Rezoning Transportation Analysis
Petition Number: Insert Zoning Petition #2021-221
General Location Identifier: 04121119

Revision Log:	Date	Description
	02-24-22	First Review (TM)

Transportation Summary

6 PROPOSED SITE PLAN
SCALE: 1"=50'-0"

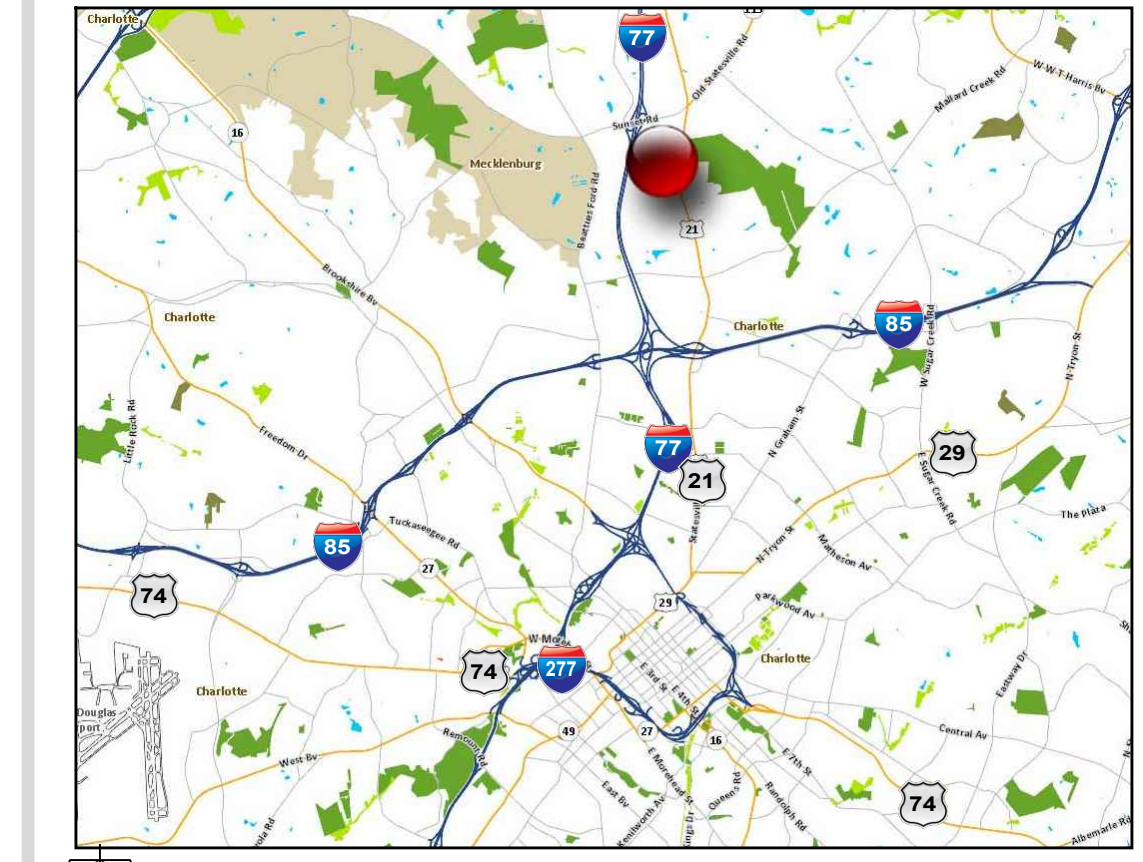
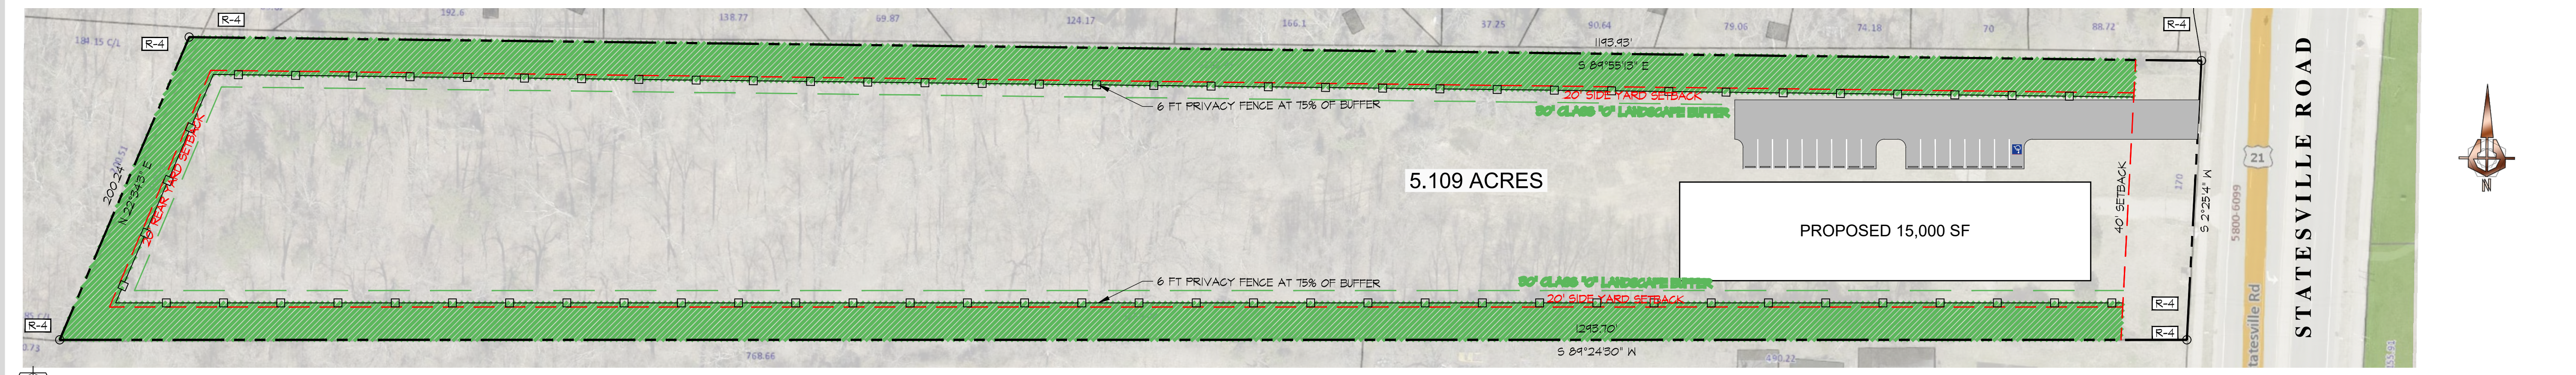
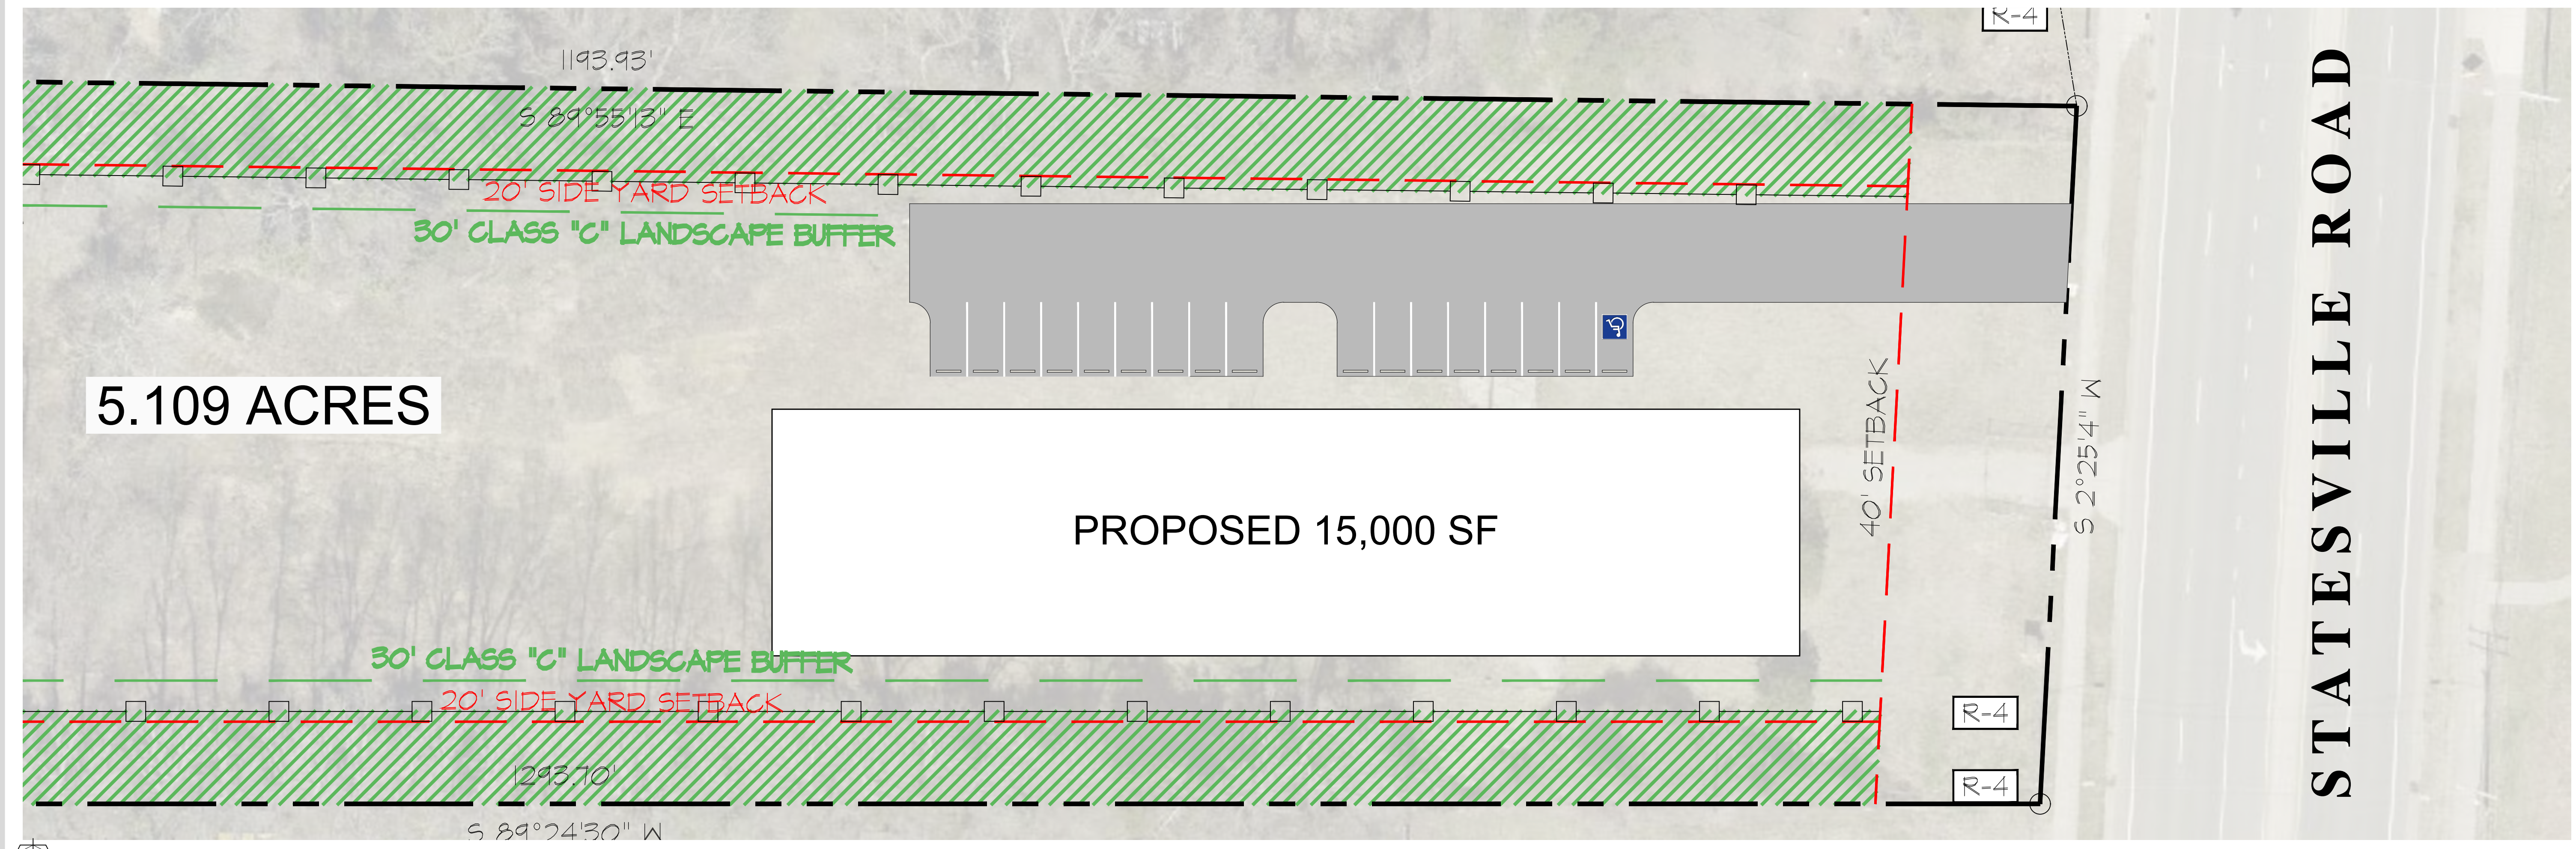
1. **Curblines:** The proposed zoning district has a setback measured from back of the existing or proposed future curblines.
 - a. **Statesville Road:** The future location of curb and gutter is in its existing location.

Label and dimension the curb and gutter from the centerline for each road on the site plan.

3. Revise site plan and conditional note(s) to commit to dedicate 50-feet of right-of-way from the road centerline. The site plan shall label and dimension the right-of-way from the road centerline.
4. Revise the site plan to dimension the driveway stem length from the right-of-way to the first parking space. A 100-ft minimum length stem length is required per the NCDOT Policy on Street and Driveway Access.

5. Revise site plan and conditional note(s) to commit to construct a Type II Modified driveway as depicted in Charlotte Land Development Standards Manual detail 10.25E connecting to the proposed parking lot.

6. Revise site plan and conditional note(s) to commit to construct an 8-foot planting strip, and 6-foot sidewalk on Statesville per the council adopted Charlotte WALKS policy. The site plan shall label and dimension both items from the back of curb and gutter and road centerline.

7. Revise site plan and conditional note(s) to commit to removal of the existing driveway and replacing the curb and gutter per the Chapter 19 Ordinance requirements. Reference Charlotte Land Development Standards Manual detail 10.17A on plan.
